Meeting note

Project name	A30 Chiverton to Carland Cross Improvement Scheme
File reference	TR010030
Status	Final
Author	The Planning Inspectorate
Date	30 May 2018
Meeting with	Highways England
Venue	Planning Inspectorate offices, Bristol
Attendees	The Planning Inspectorate Susannah Guest – Infrastructure Planning Lead Richard Price – Case Manager James Bunten – Case Officer The Applicant Josh Hodder – Project Manager (Highways England) William Spencer – DCO and Statutory Process Manager (Highways England) David Grattan – DCO Lead (Arup) Michael Baker – Stakeholders and Land Lead (Arup) Jessica Postance – EIA Lead (Arup) John Arthur – Lawyer (Burgess Salmon)
Meeting objectives	Draft document feedback and project update meeting
Circulation	All attendees

TR010030: A30 Chiverton to Carland Cross Improvement Scheme

Draft documents review

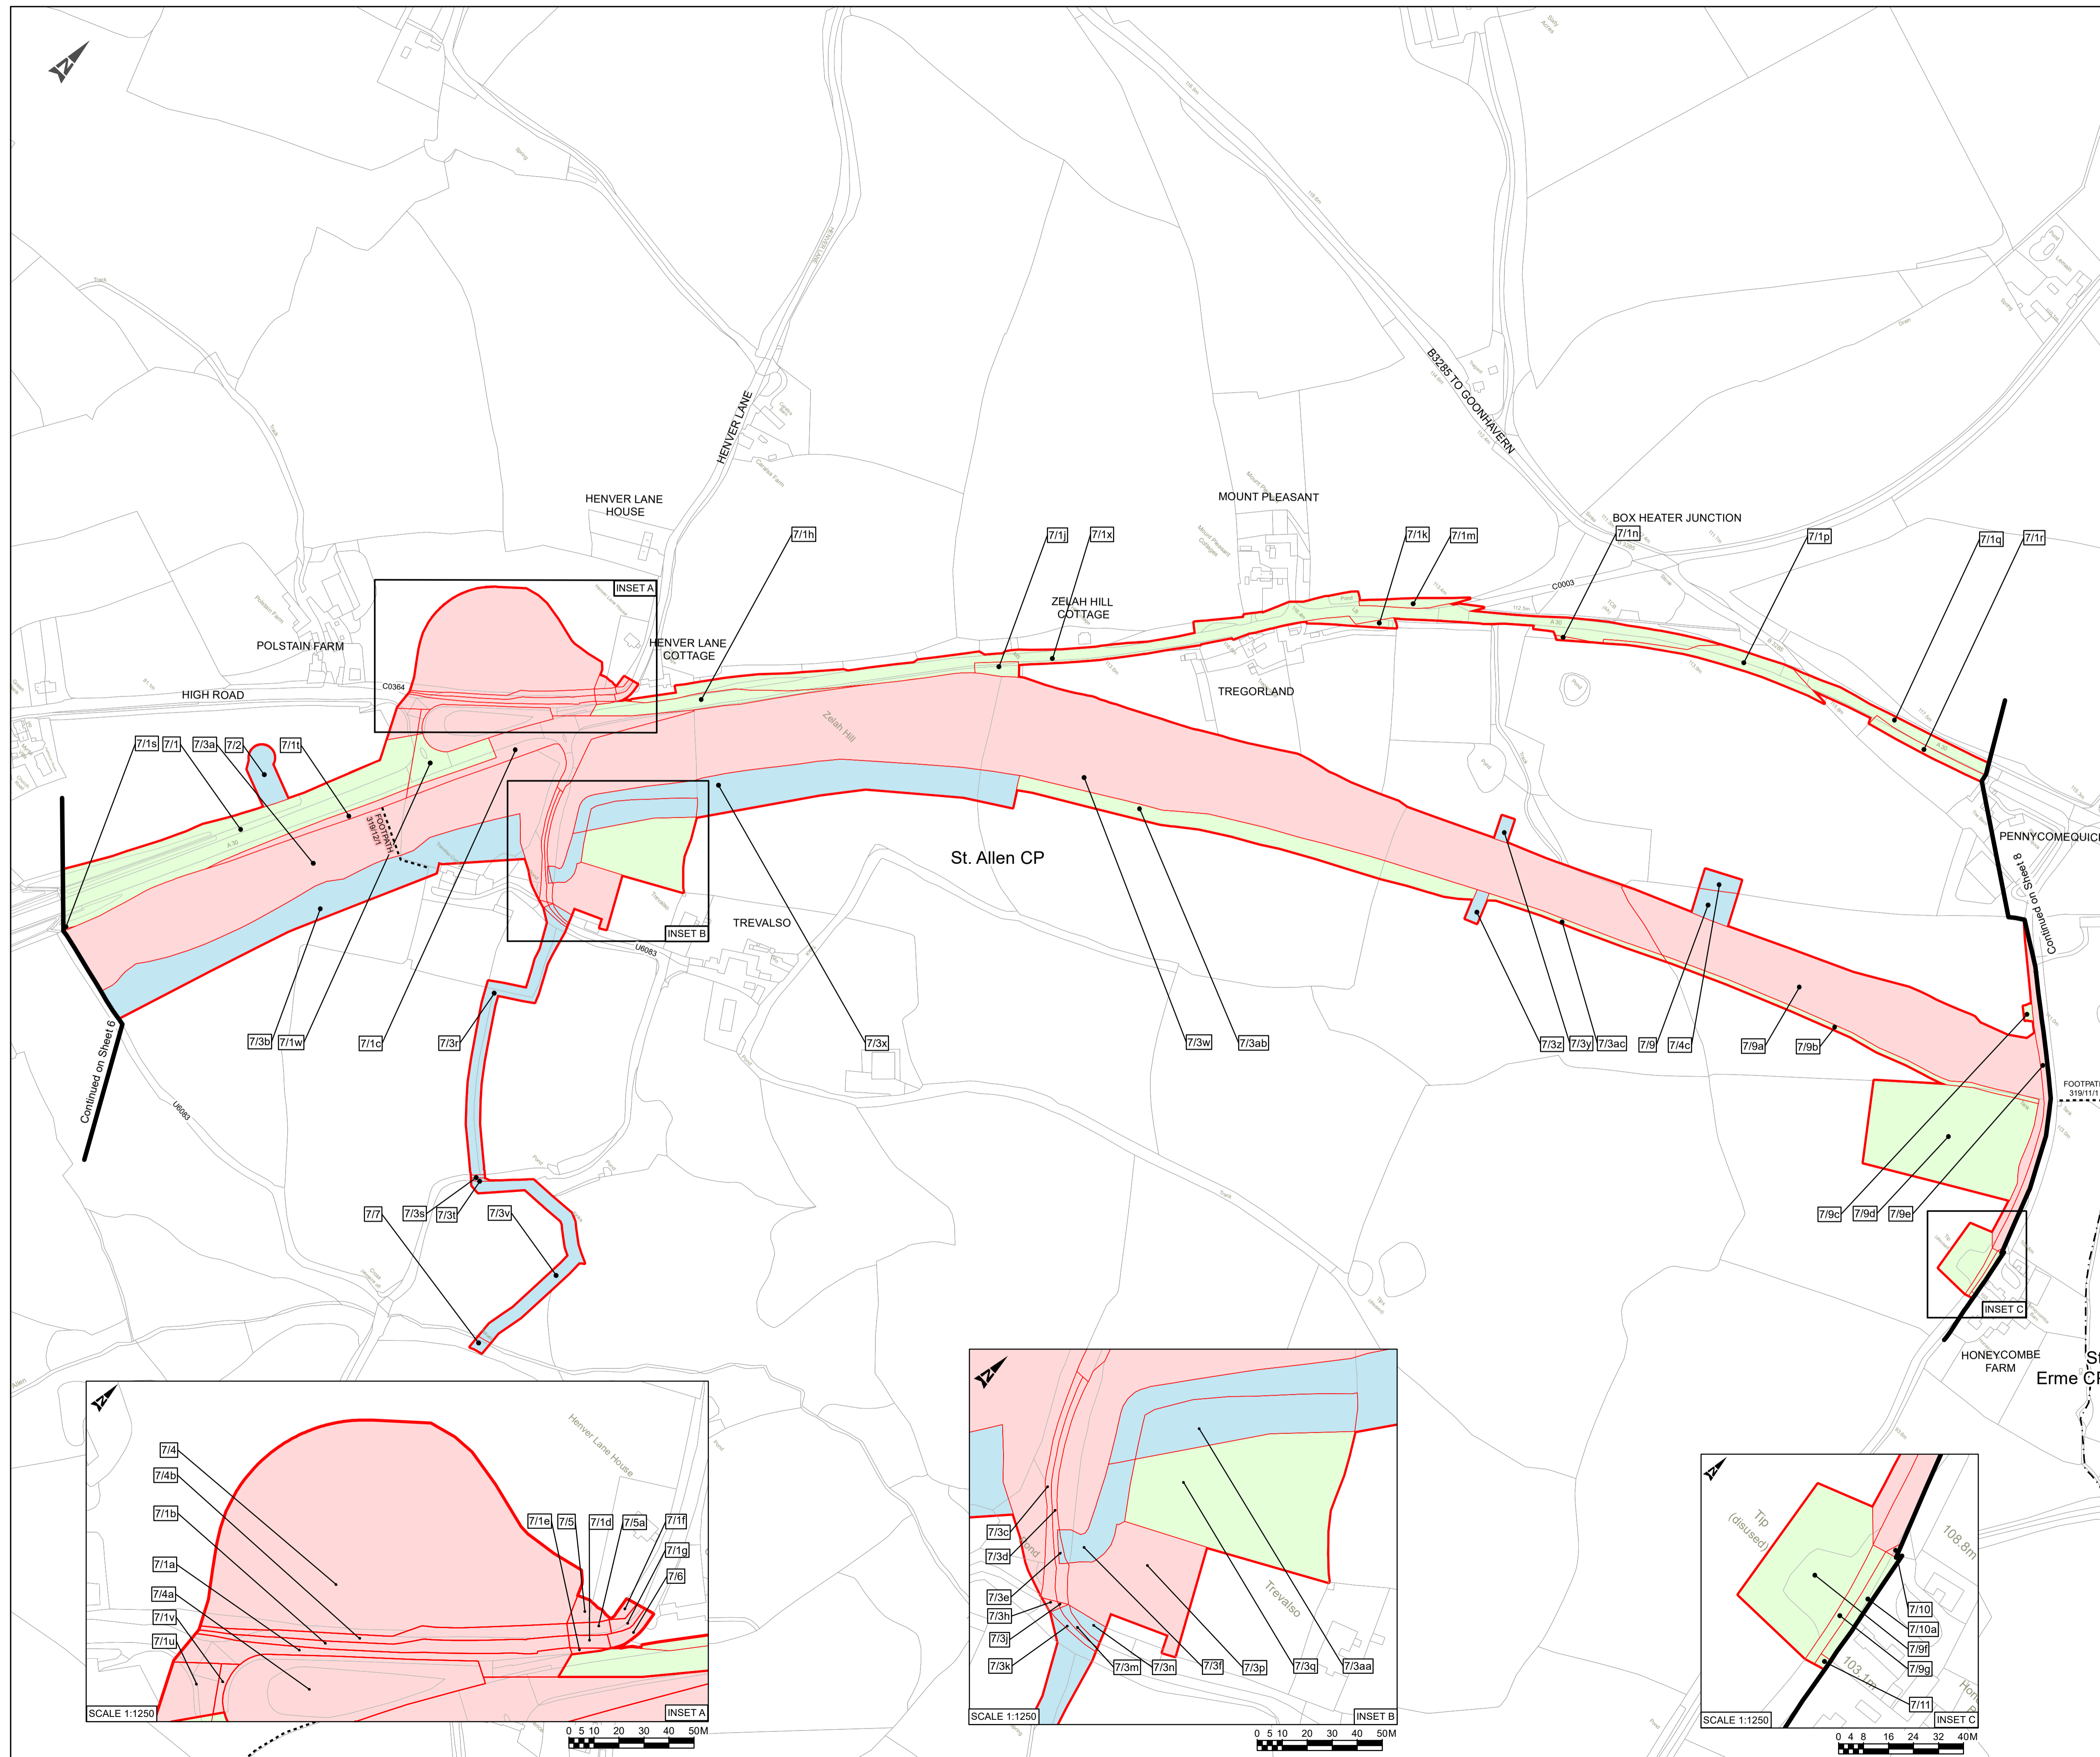
- The thickness of the red line boundary can make it difficult to view some of the smaller plots located on the edge of the site.
- Although the majority of the plot descriptions within the Book of Reference appear accurate, there are a few instances of landmarks used that are not identified on the correlating land plan.
- It would be helpful to have insets on the land plans when there is a concentration of smaller plots and it is hard to make each individual plot boundary.
- There is an unidentified plot located on sheet 6 of the land plans, directly above plot '6/9'.
